# Mallard Pass

### Environmental Statement Volume 2 Appendix 2.2: Scoping Opinion

## **Proposed Mallard Pass Solar Project**

**Case Reference: EN010127**

DWG. NO. Figure 2.1

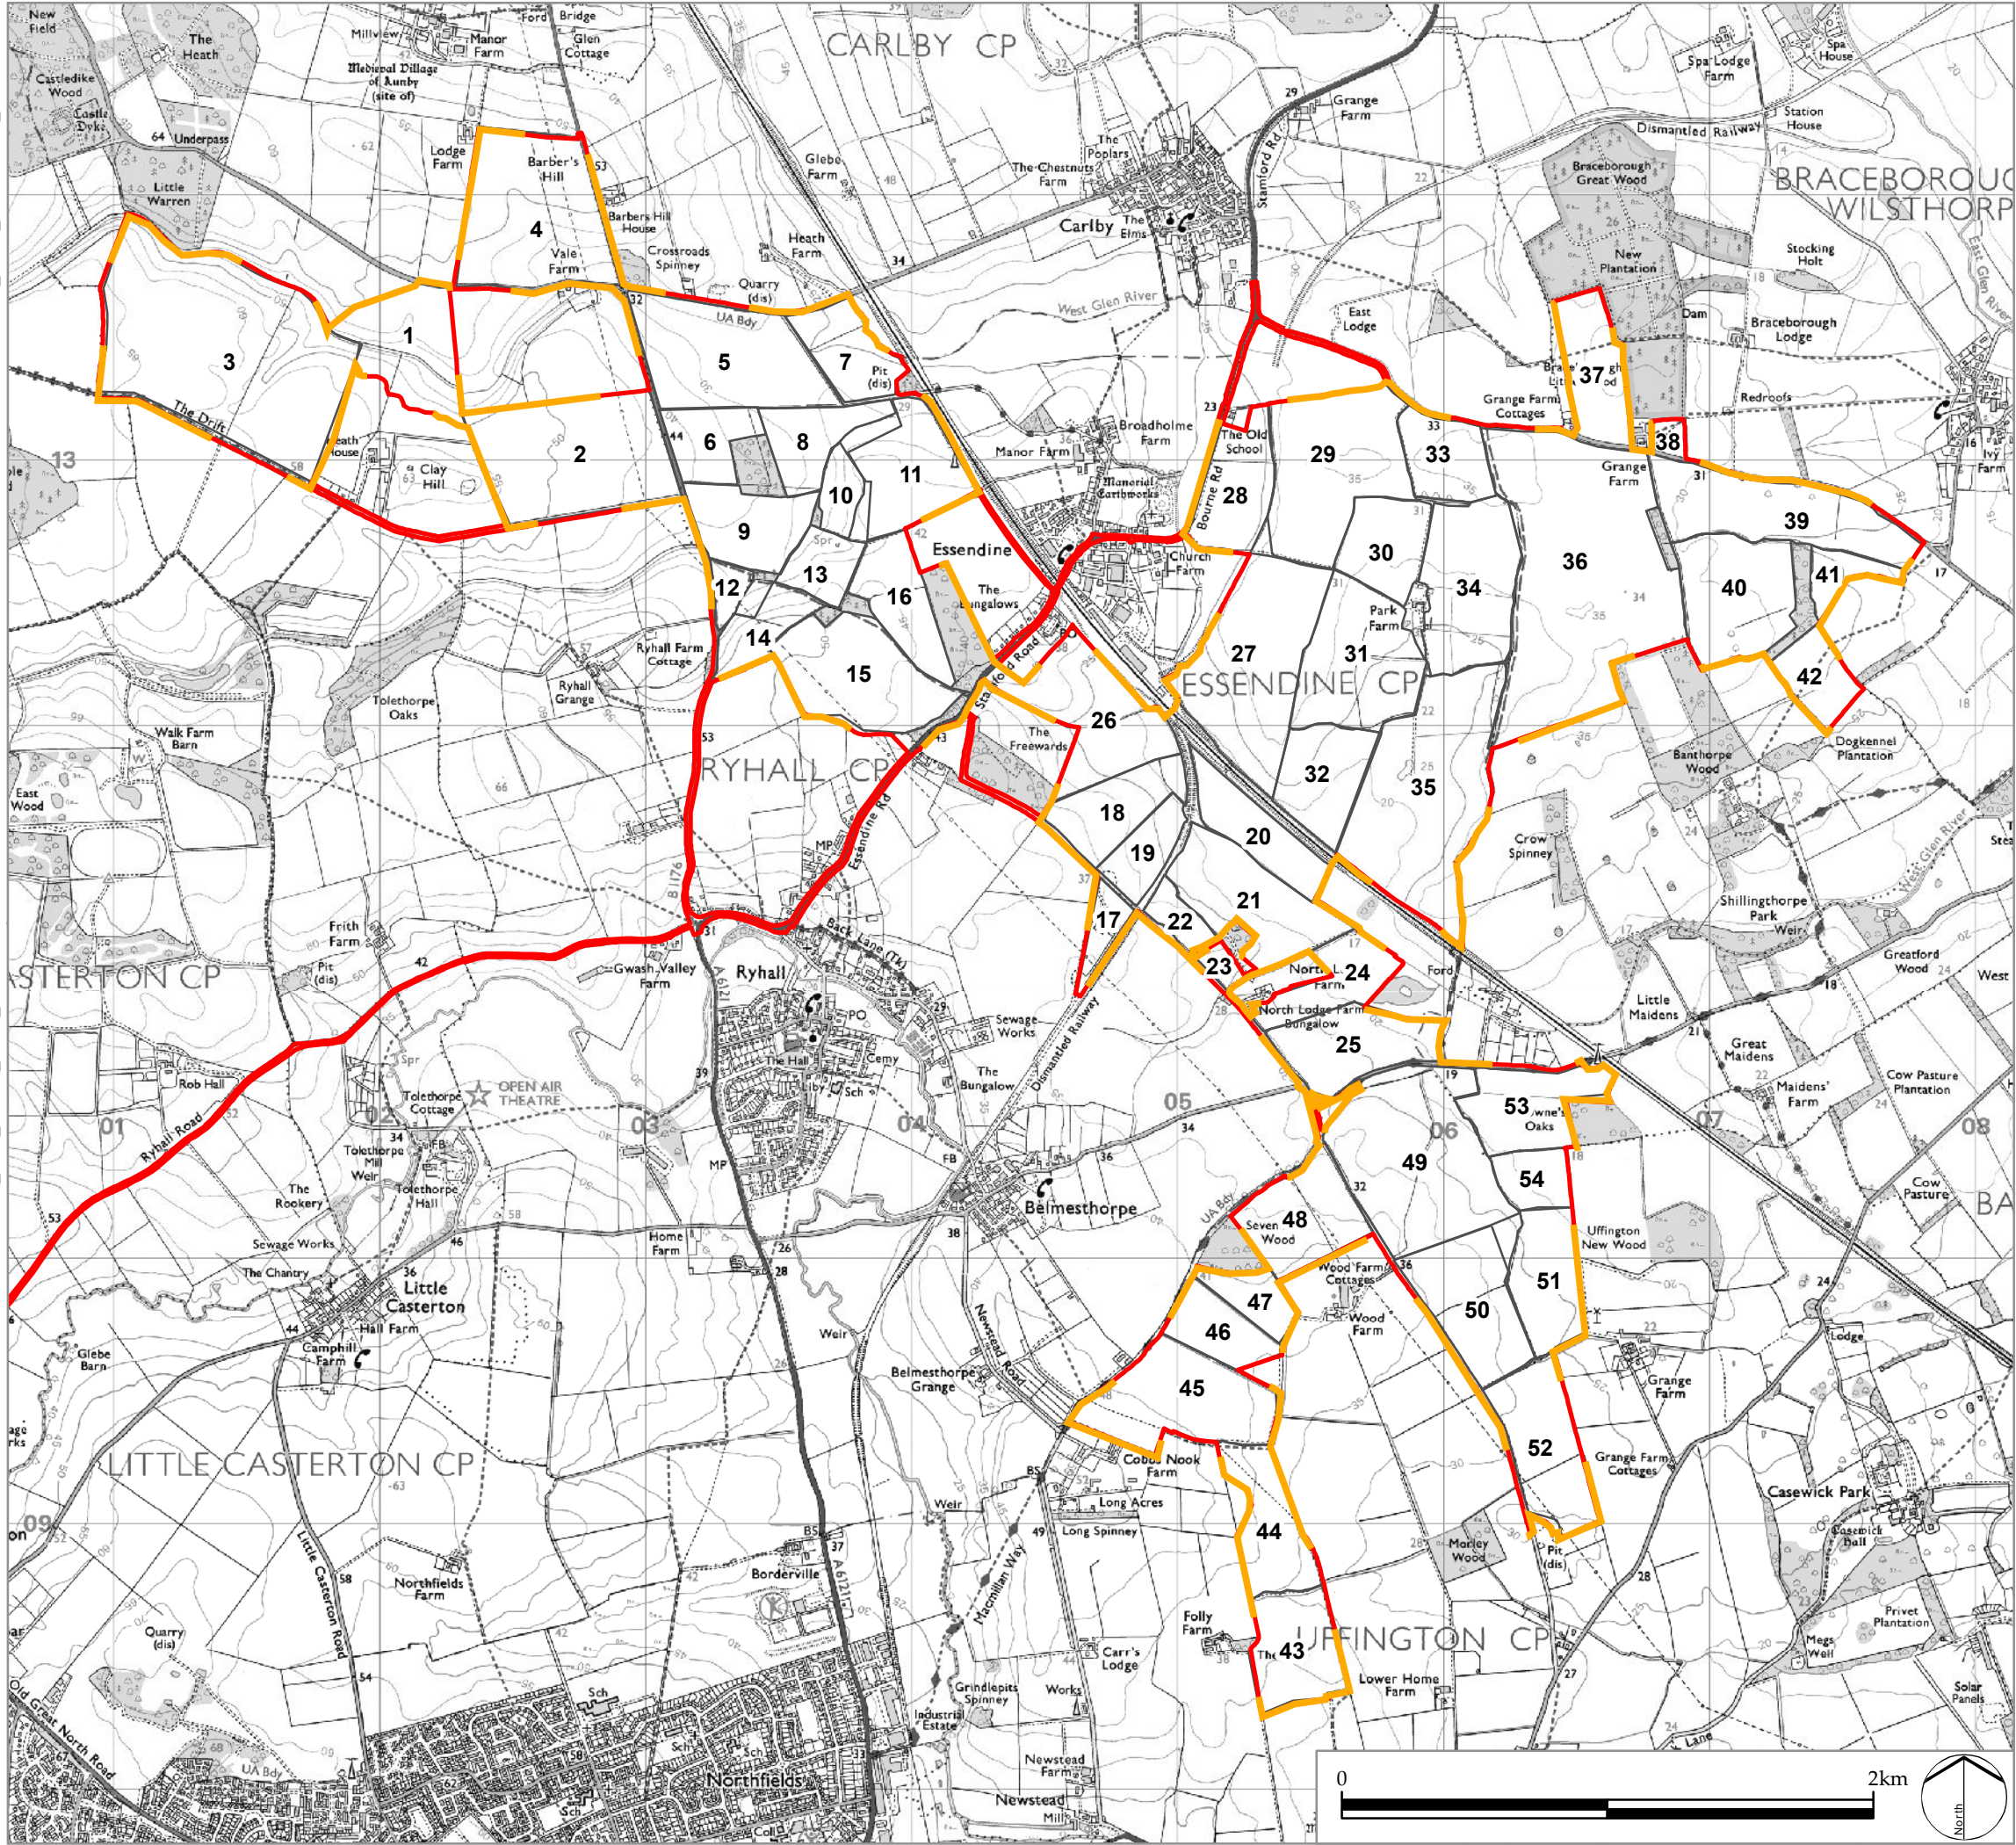
ID	Ref	Description	Inspectorate's comments
2.1.1	Figure 2.1	Site Location Plan	The site location plan depicts the site boundary, which includes the whole of the Proposed Development and the Solar Photovoltaic (PV) site boundary (the area for the panels). The boundary lines overlap in places and the same or similar key colours are used, which prevents a full understanding of how the boundary of the Proposed Development relates to the solar PV site. In addition, certain fields or sections of fields within the site appear to be excluded. The ES should include a figure or figures that clearly set out the Proposed Development boundary and the land included therein.

## DWG. NO. Figure 2.3

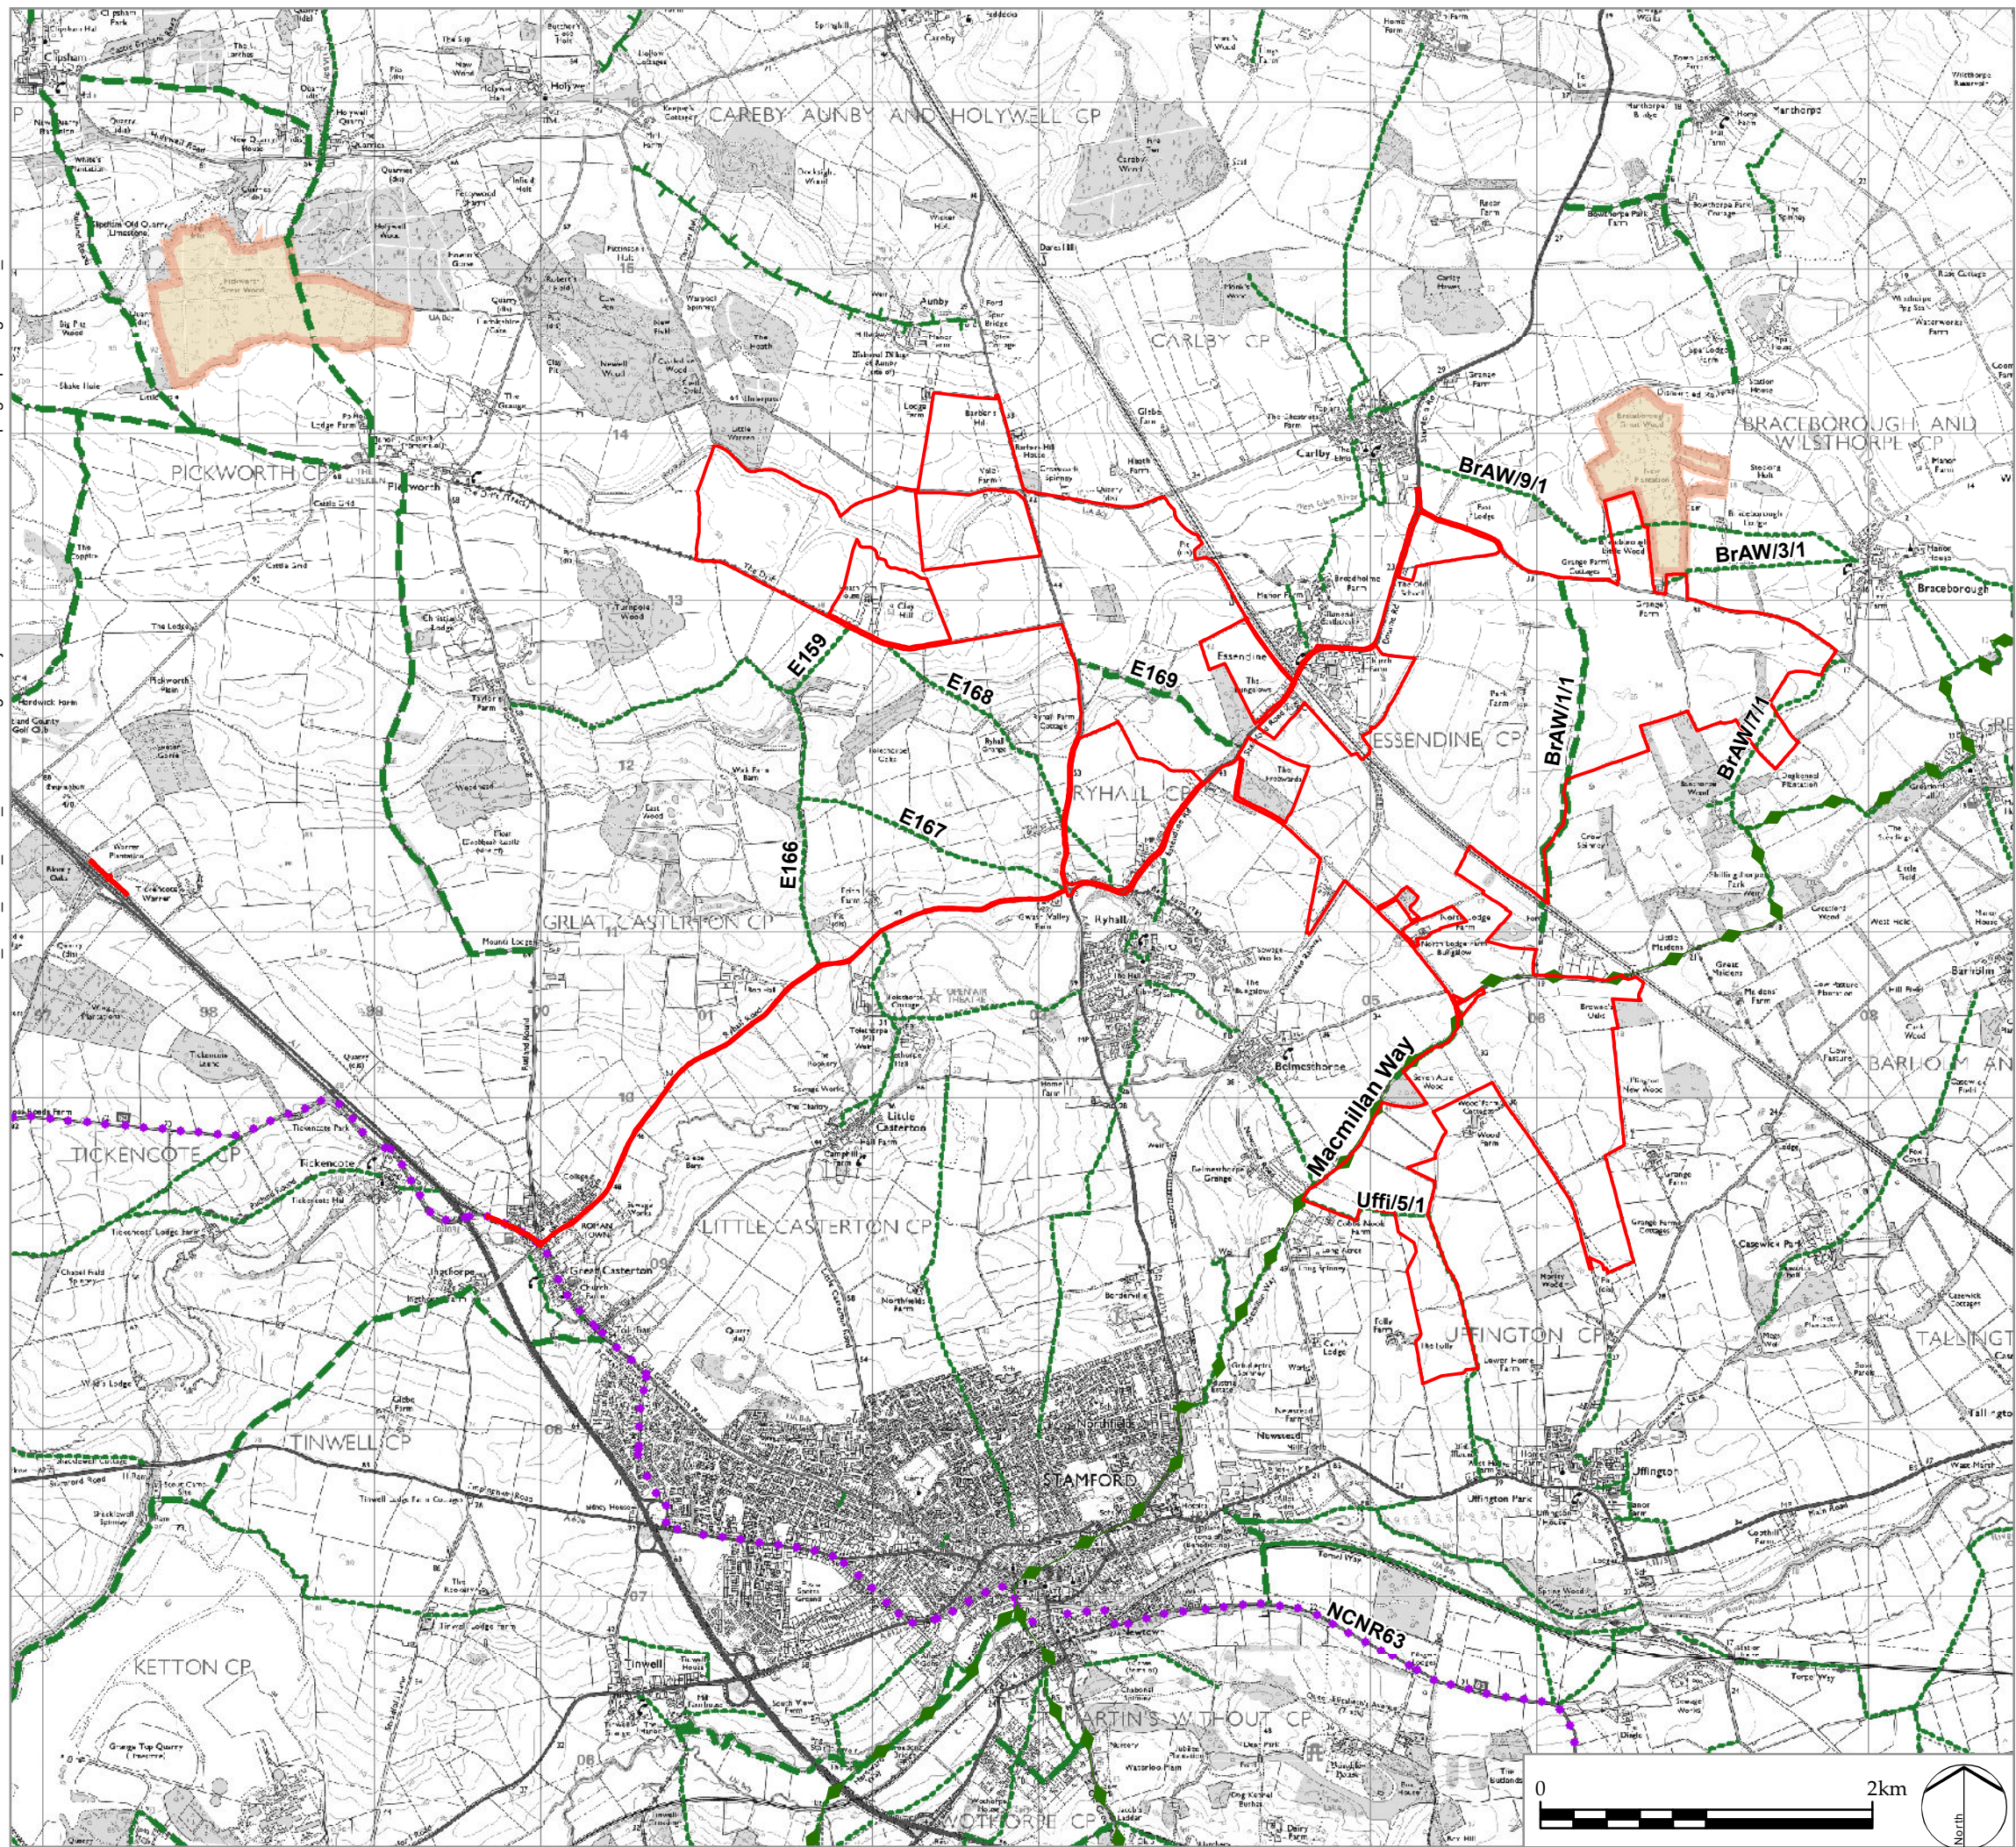
2.1.2	Figure 2.3	Topography	The topographical plan included in the Scoping Report lacks clarity regarding the land that is included in the redline boundary. It appears that certain field areas have been excluded from the red line boundary. The ES needs to include plans which clearly show the land required for the Proposed Development.
